Regiment Redevelopment Project

Community Consultation Report

December 2016

Local Pedestrian Movement Networks

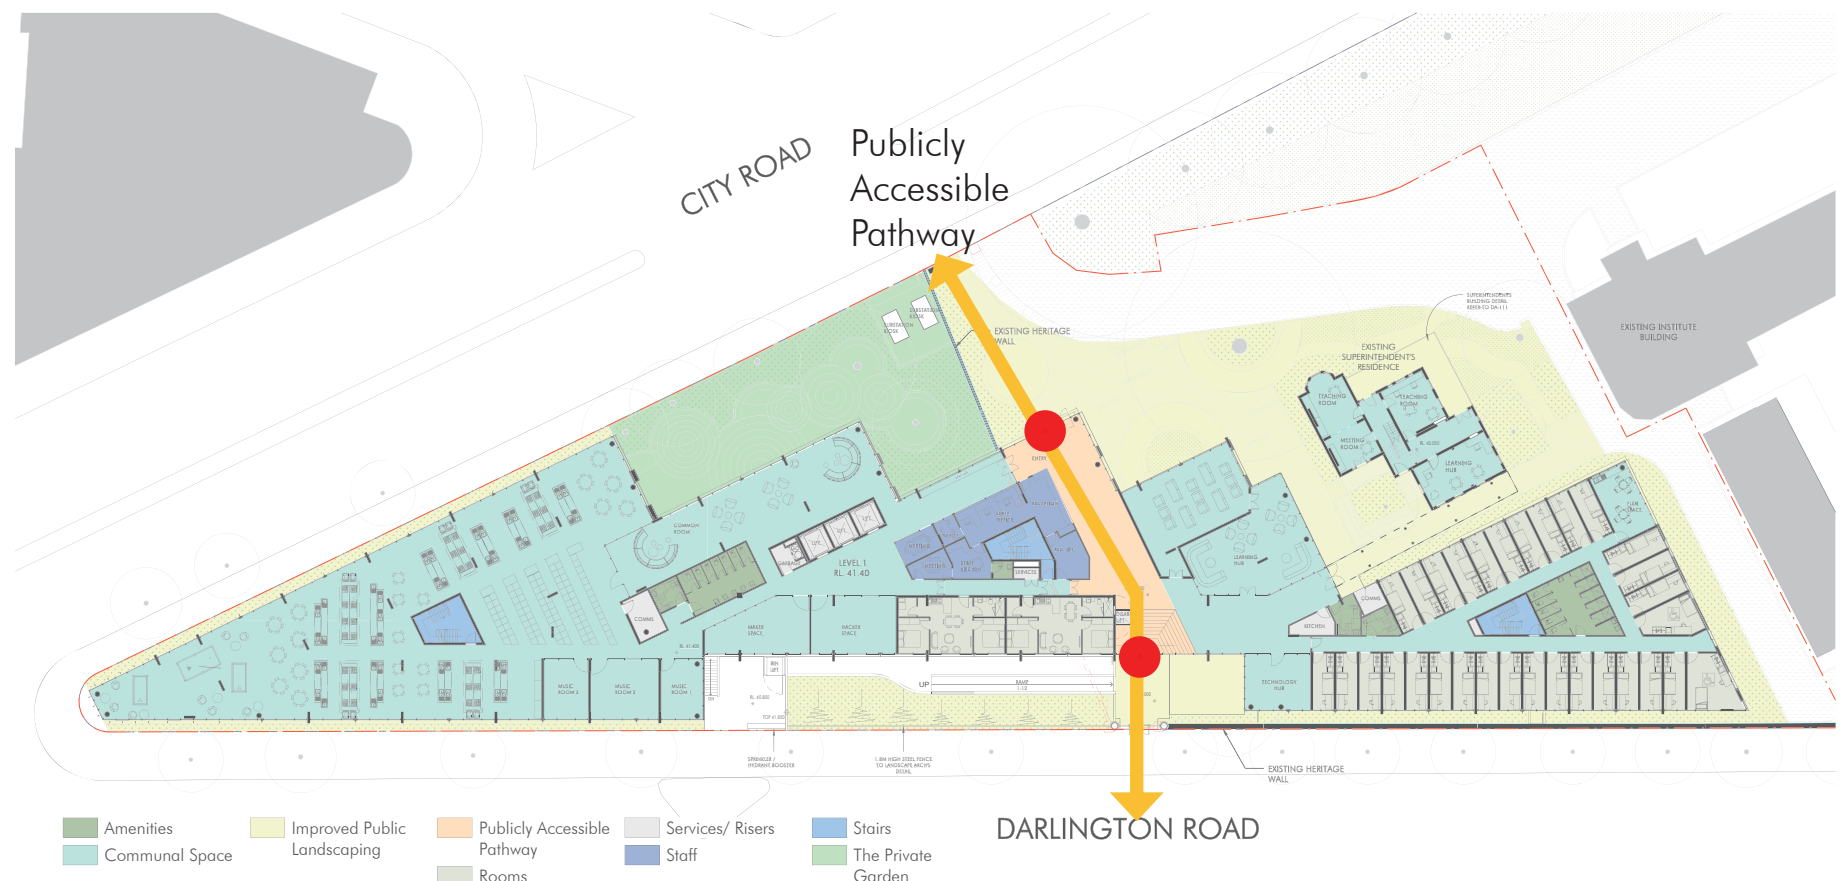
Issue - Public Site Through Link: Concerns were raised on how we propose to make the public site through link from Darlington Rd to City Rd look more inviting to general public. Residents feel that the current design does not appear to be a public access way and needs to be more welcoming / defined as a public access area.

Resolution – Nettleton Tribe will investigate opportunities to improve the visual connection through to City Rd and make the access way more inviting to the public.
